WEST SUSSEX COUNTY COUNCIL CONSULTATION

TO:	Arun District Council FAO: Miss K Welch
FROM:	Highways, WSCC
DATE:	16/06/2026
LOCATION:	56-57 Pier Road, Littlehampton, BN17 5LP
SUBJECT:	LU/134/26/DOC Approval of details reserved by condition under LU/139/23/PD relating to condition 2- Cycle Parking.
DATE OF SITE VISIT:	N/A
RECOMMENDATION:	Advice

Condition 2 – Cycle Parking

PROPOSED BASEMENT FLOOR PLAN 1:50
(showing location of secure cycle store)

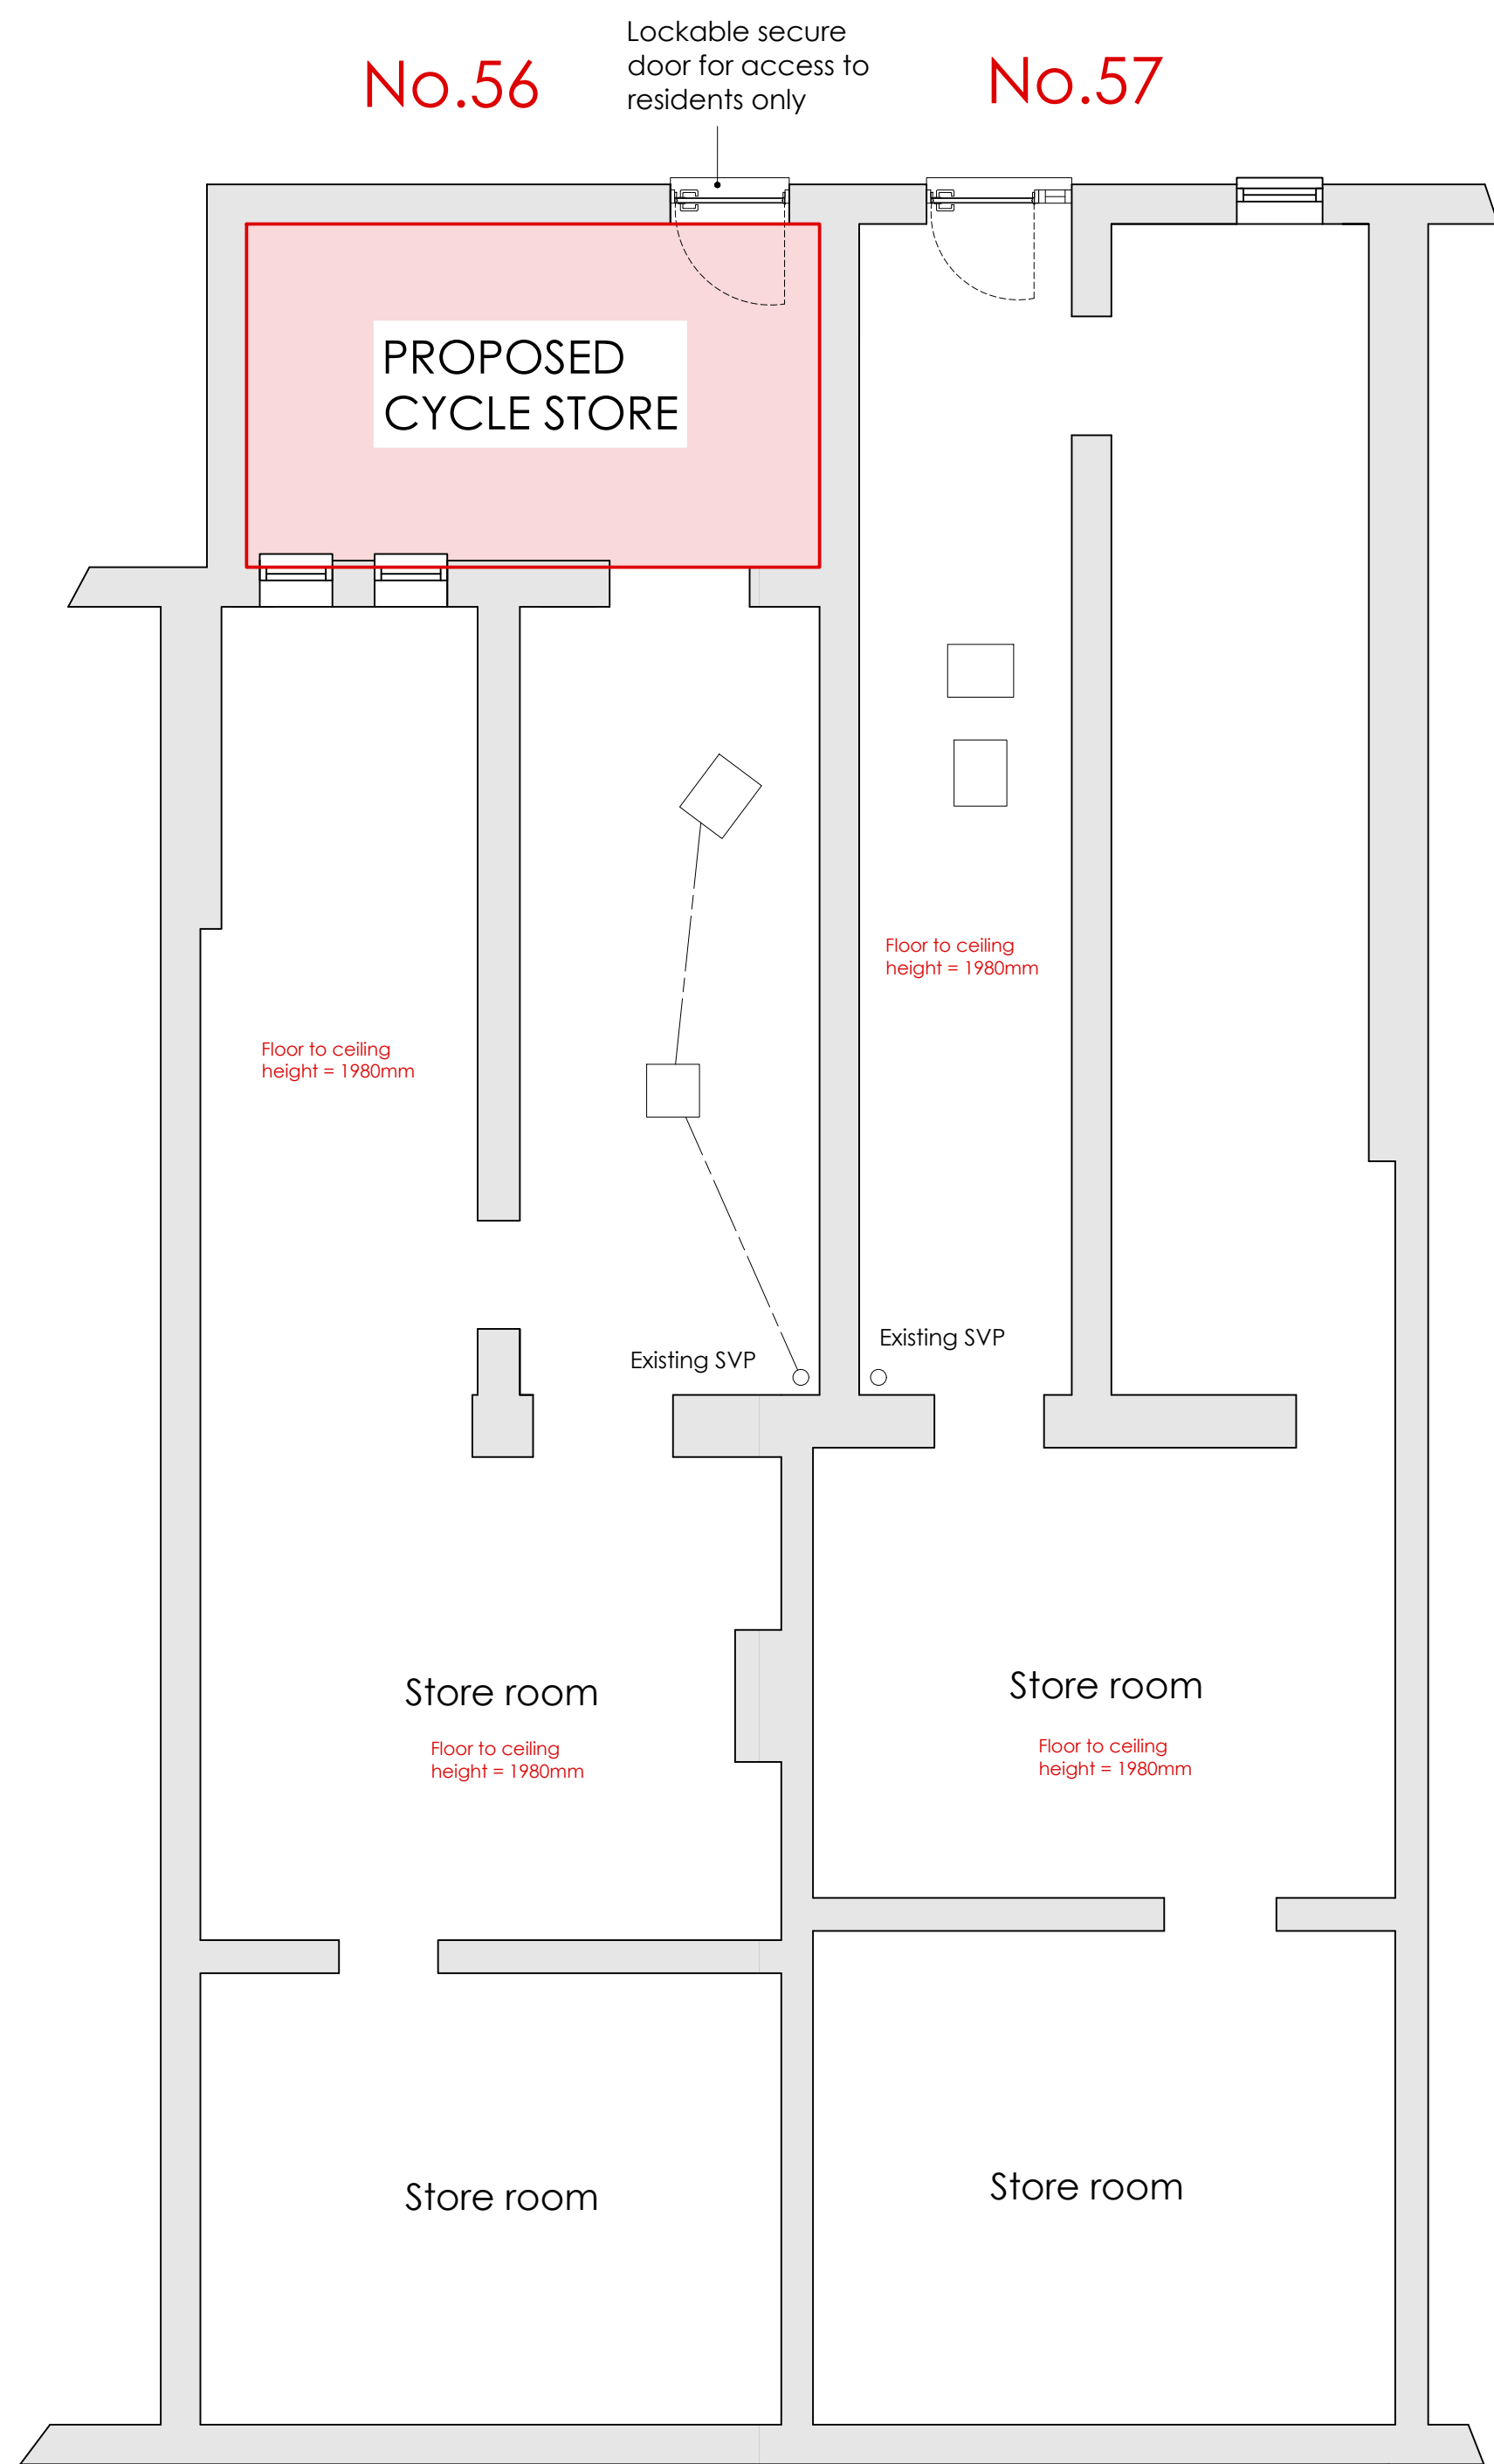
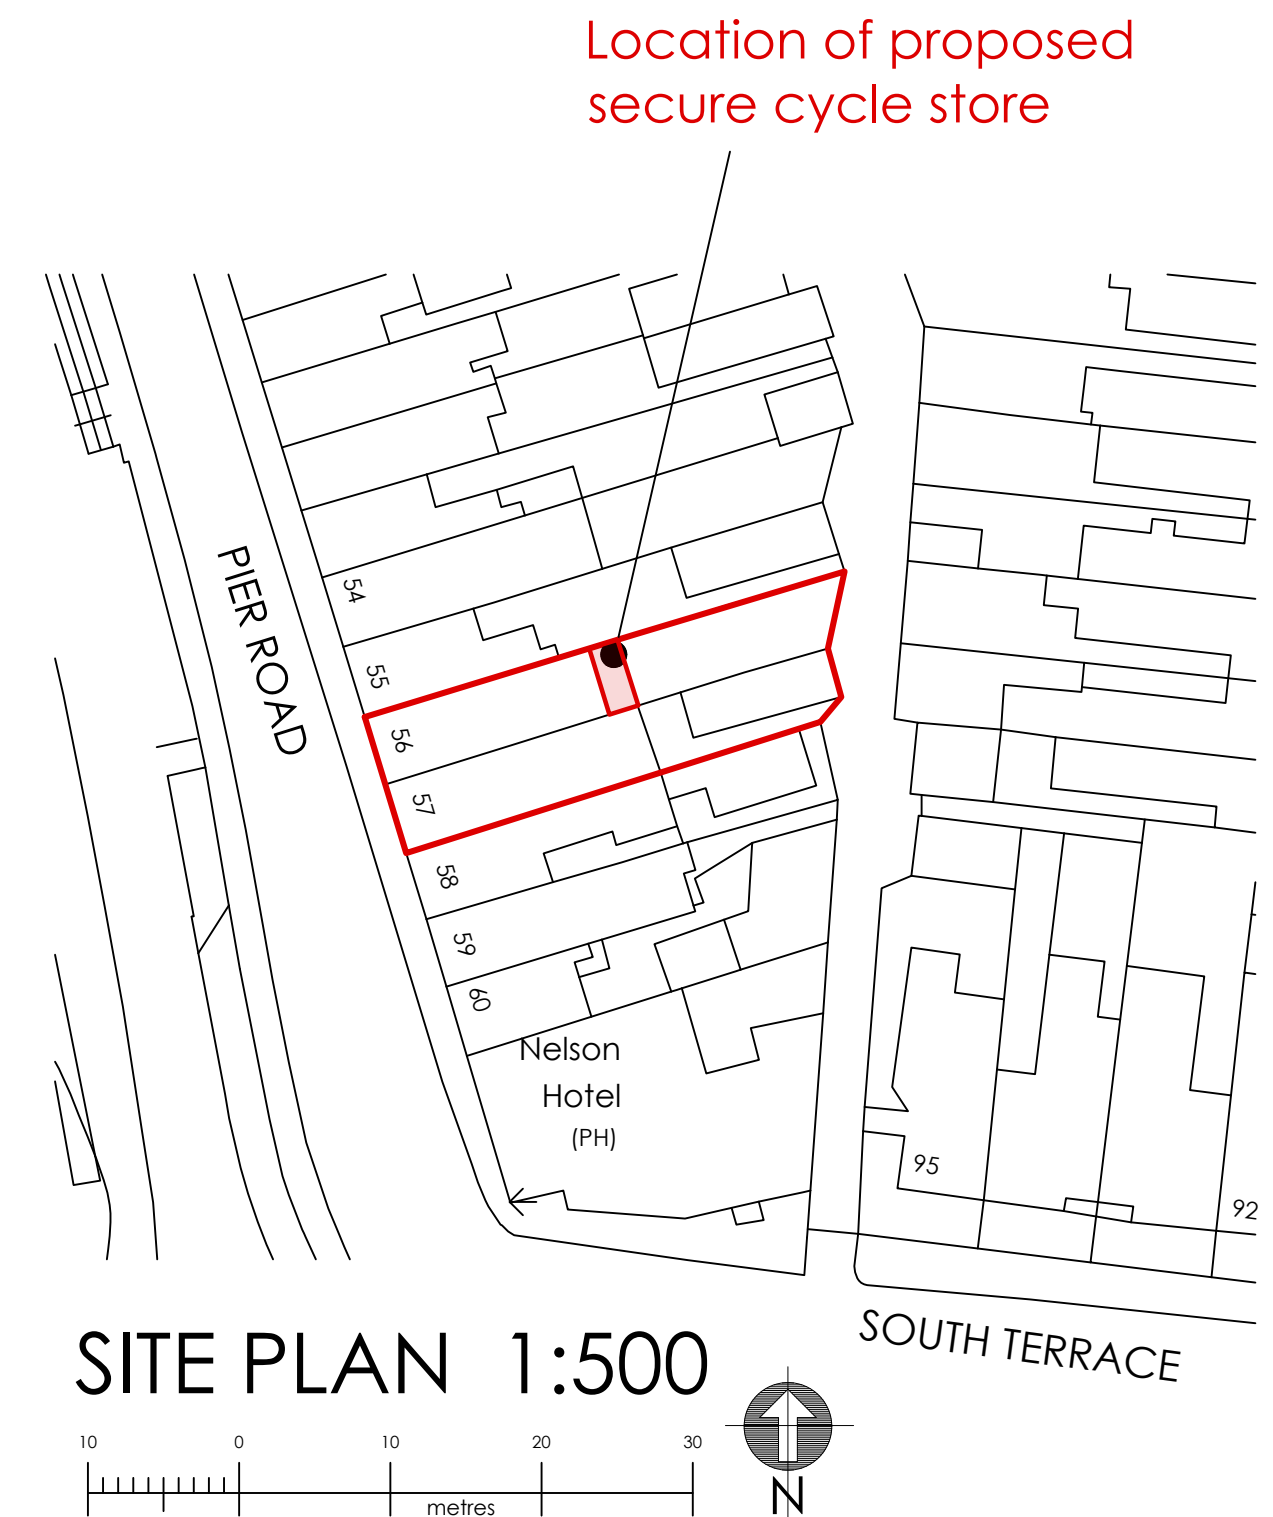
The applicant has submitted a plan (AR-172-PC-01) demonstrating the location of the proposed secure cycle store, accessed via the rear car parking area. Supporting photographs have been provided demonstrating the installation of bicycle hoops within the cycle store.

In summary, the LHA are satisfied with the details provided in regards to Condition 2.
